Our Ref: LU/152/19/HH
Your Ref:

Town & Country Planning Act 1990 (as amended)
Town & Country Planning (Development Management Procedure) (England) Order 2015
Application for Planning Permission for Works or Extension to a Dwelling

Development Two storey side extension and single storey rear extension (Amendment to LU/255/18/HH)
Location 64 Cornwall Road Littlehampton

DRAWING TITLE
PROPOSED ELEVATIONS

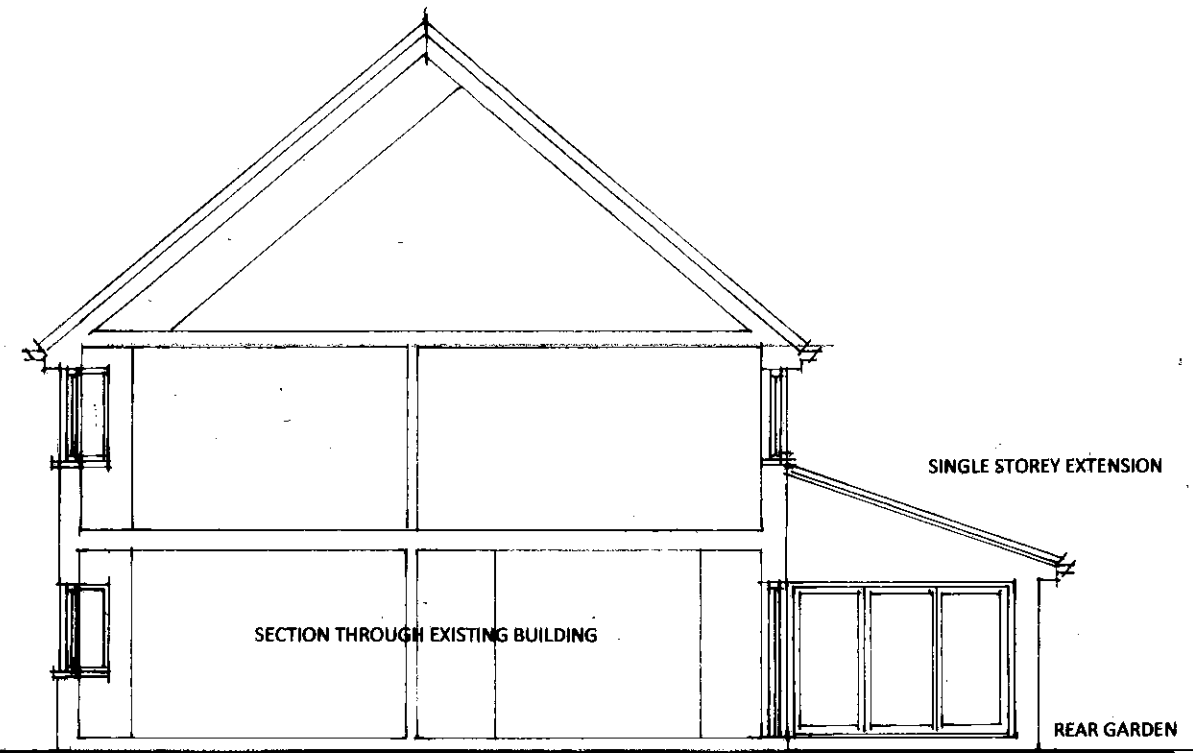
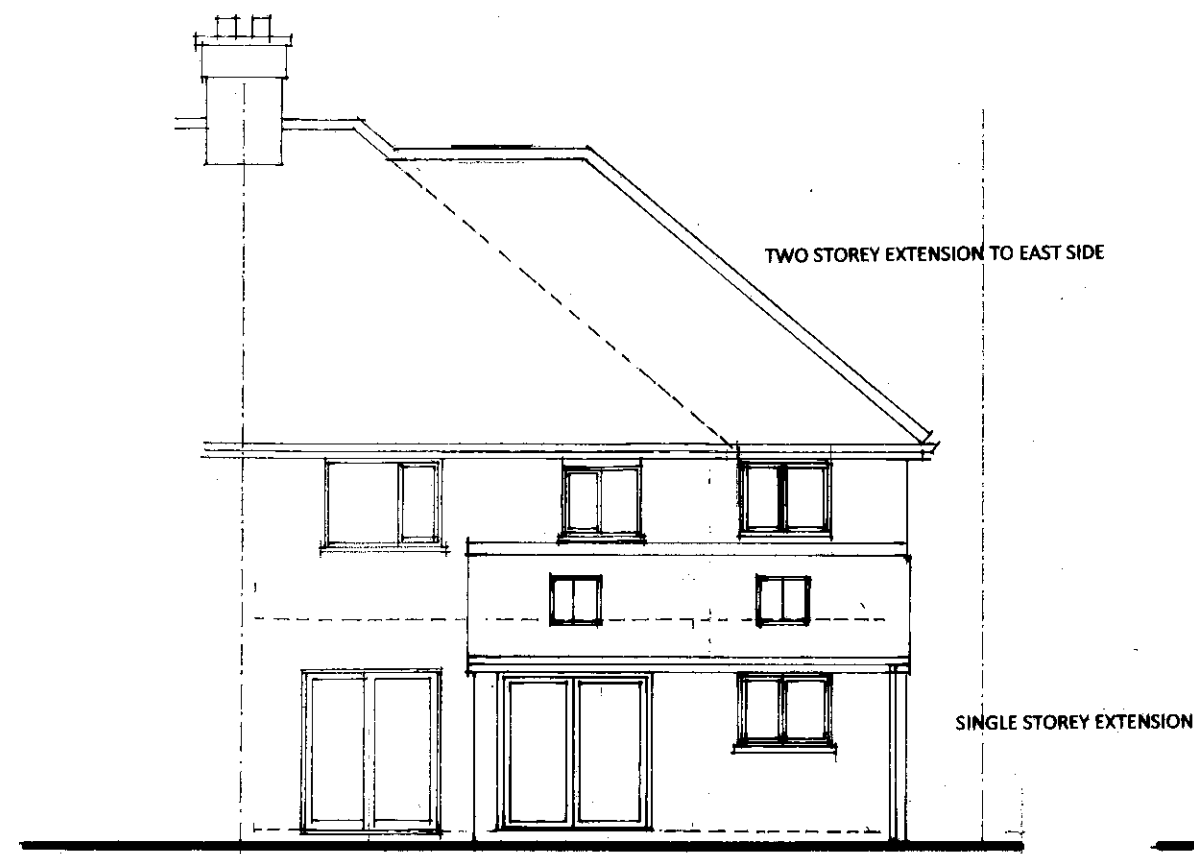
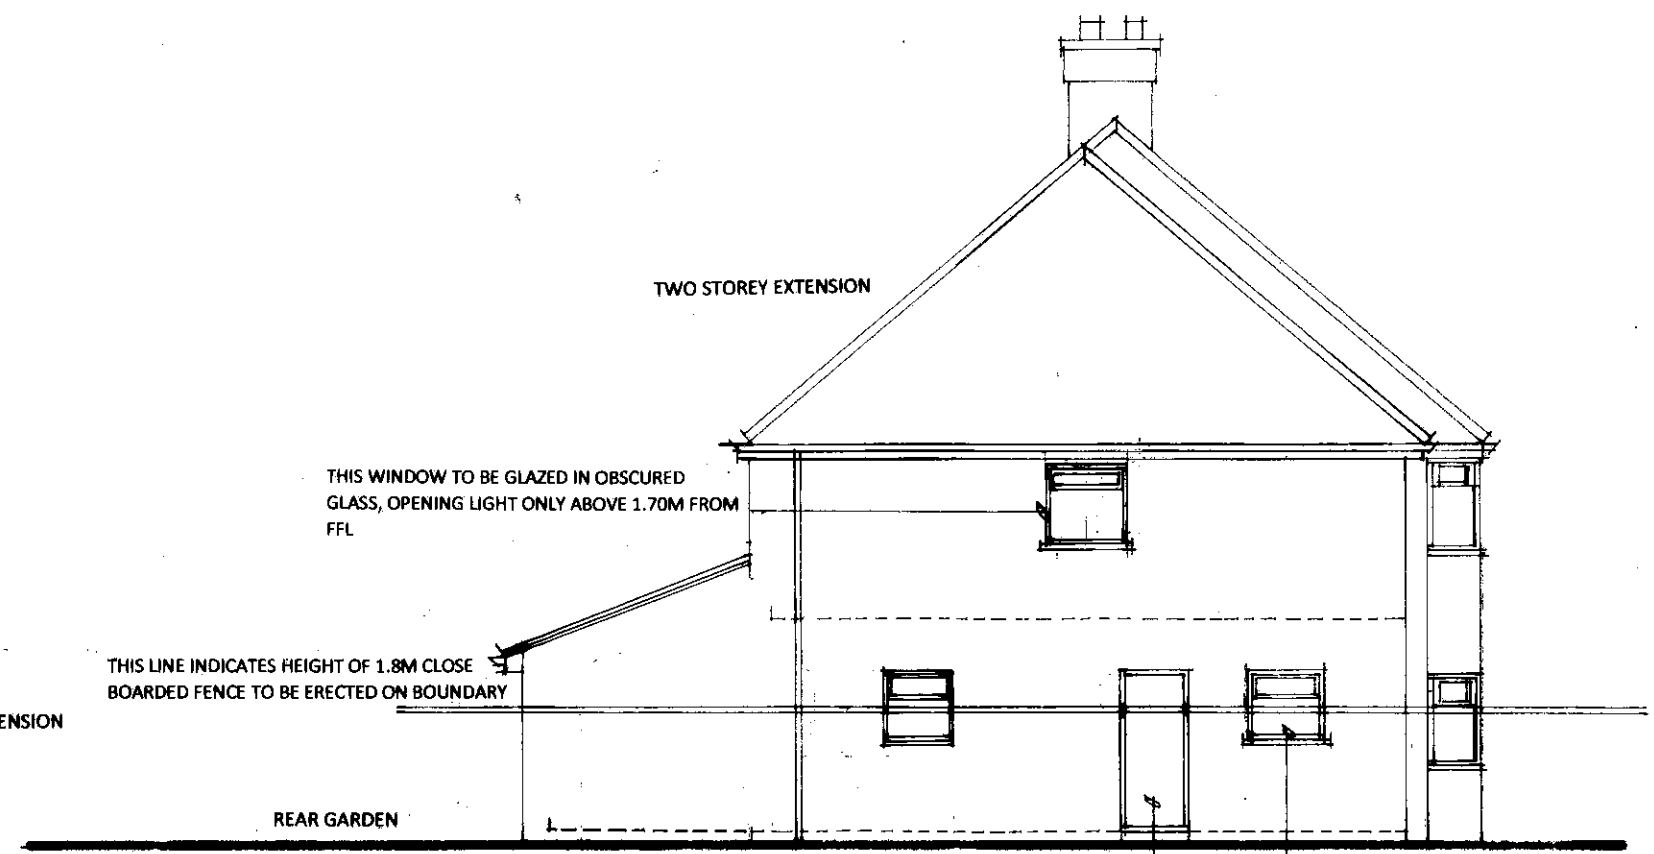
You have also submitted a proposed floor plan showing a loft conversion. Please clarify whether this is part of the proposal. The description will need to include this, and the rooflights will need to be shown on the proposed elevations to match with the loft floor plan.
